FG/180/21/PL

Upgrade of the existing radio equipment incorporating; the replacement of the existing 13.8m Mast and associated antennas with a new 20m Mast, antennas and ancillary support units, and development works ancillary thereto, including the upgrade of the existing cabinets. This application is in CIL Zone 4 (zero rated) as other development.

Adjacent to Greystoke Road Ferring BN12 5JL.

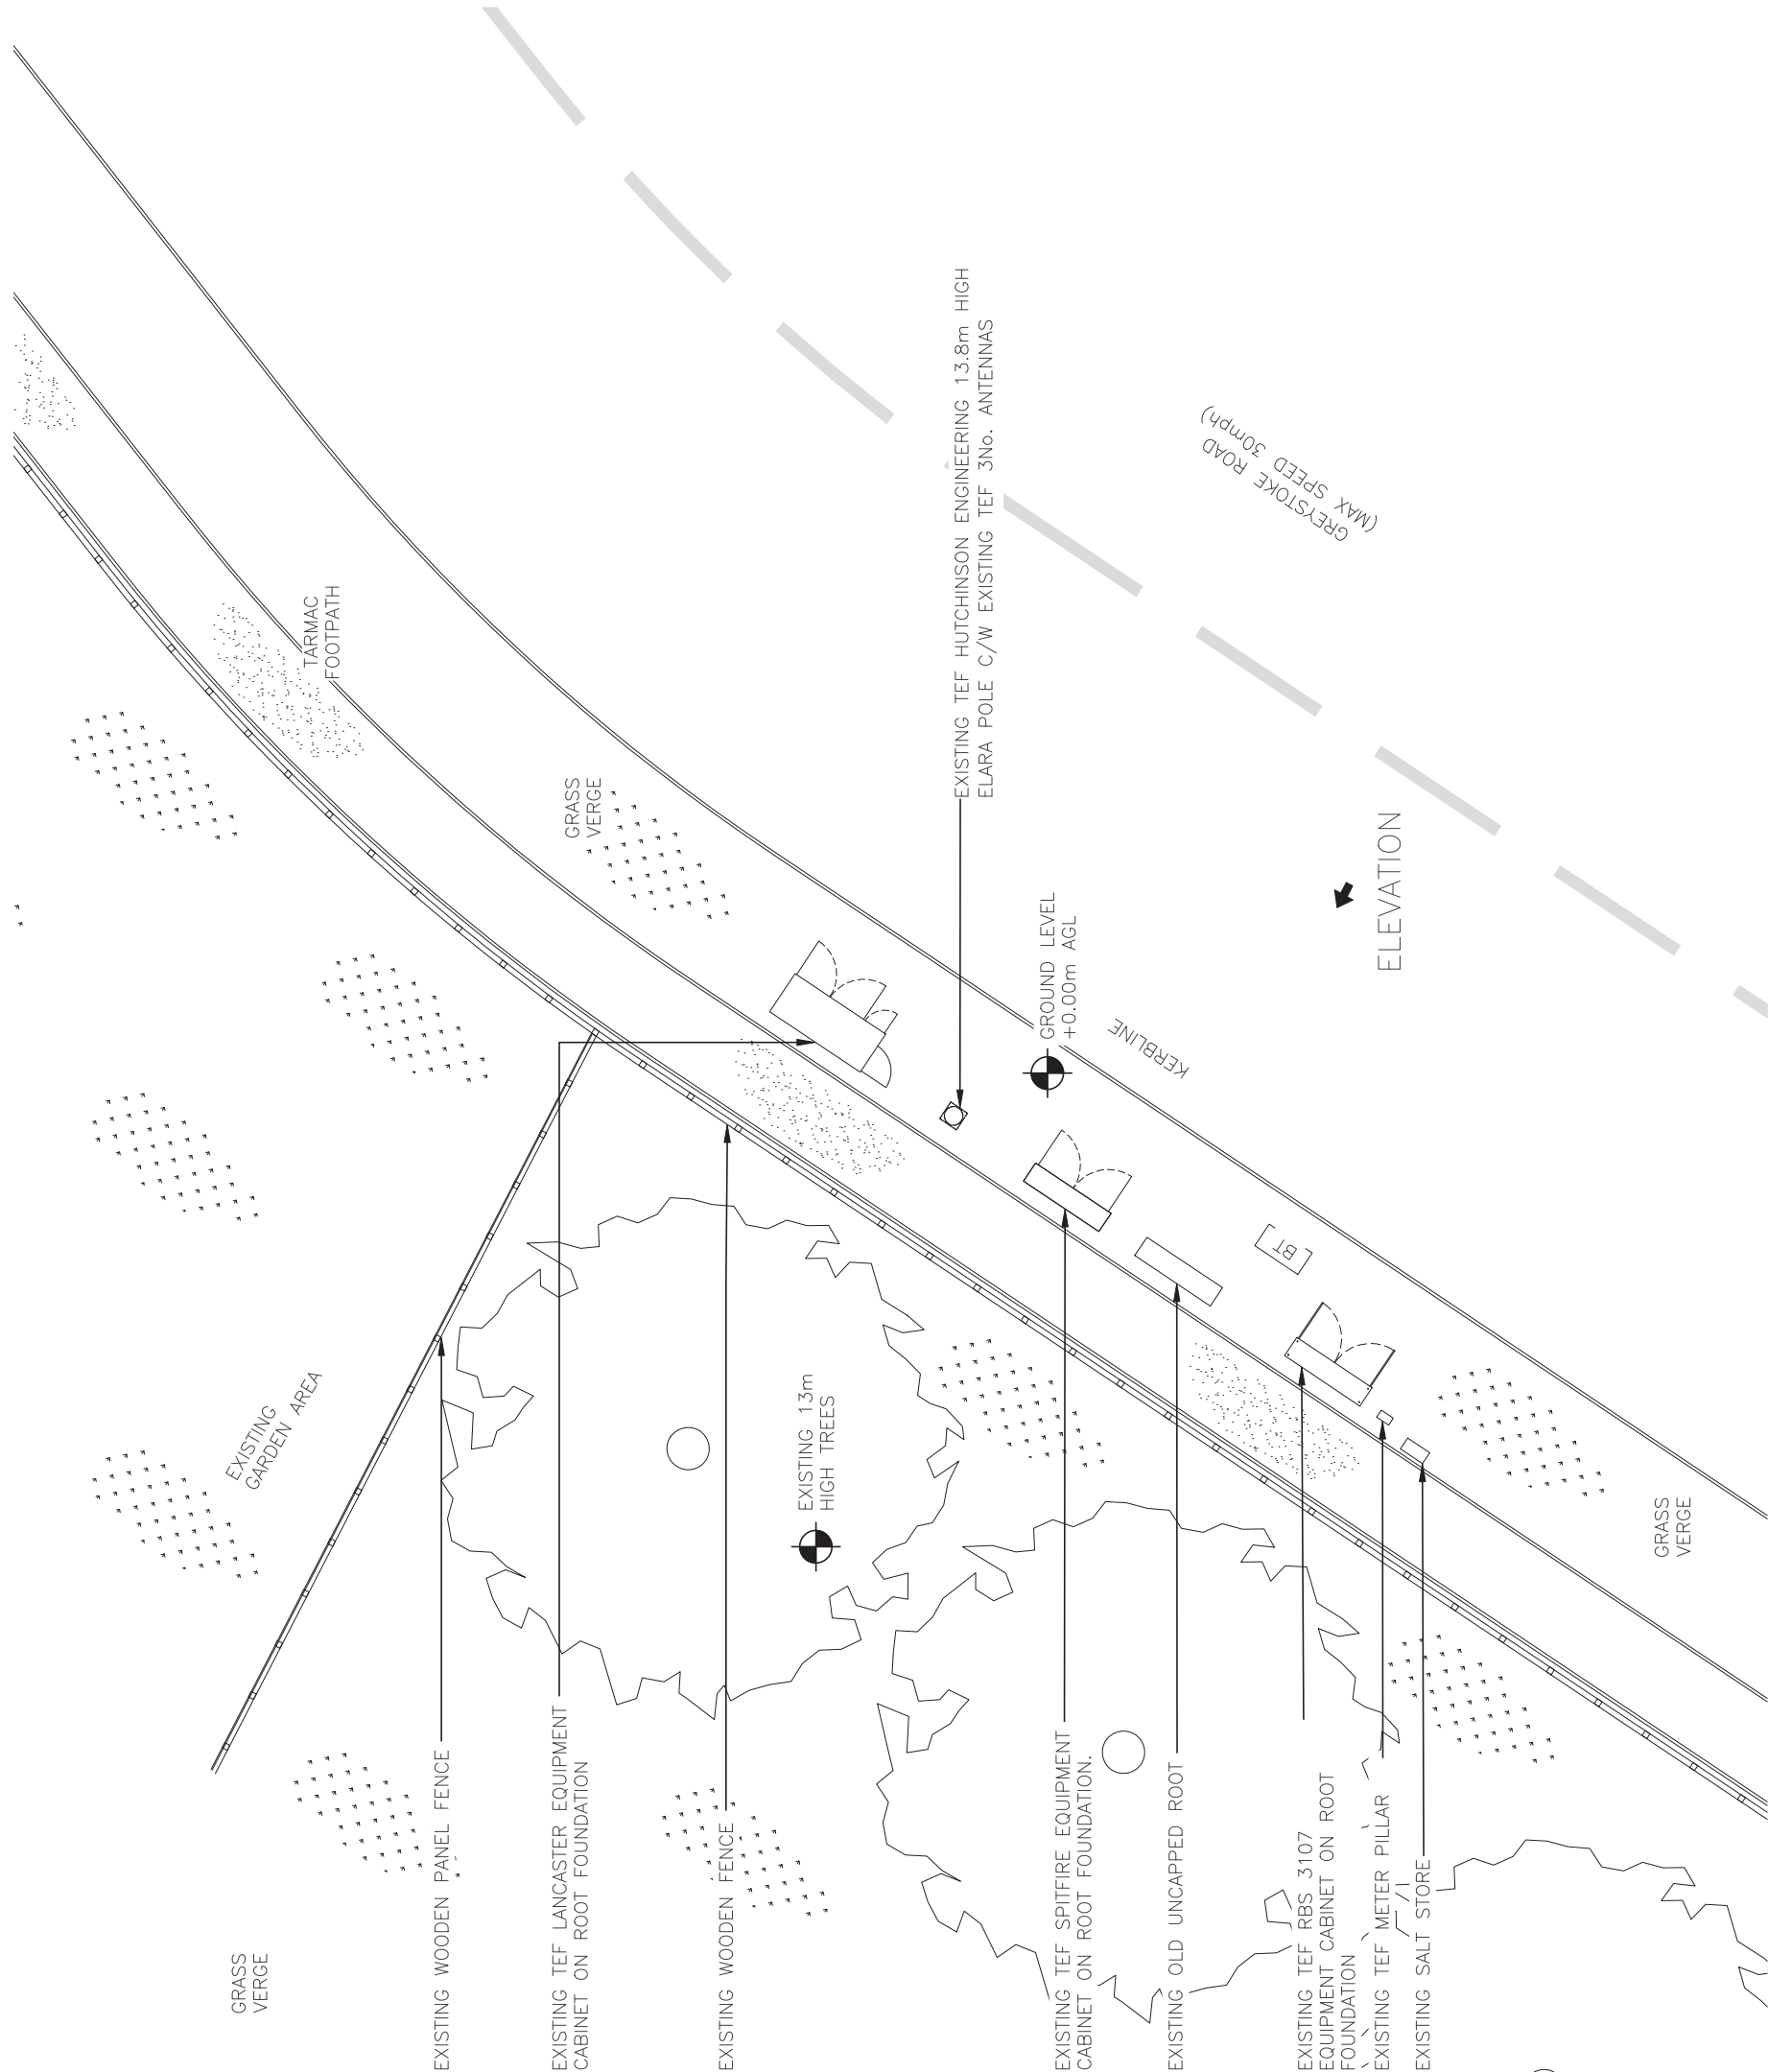
At present, it is not clear if the increased height of the mast (which appears to be a large increase in height) would be visible from within the conservation area, such as glimpsed views, and therefore what impact this would have on the significance of the assets identified.
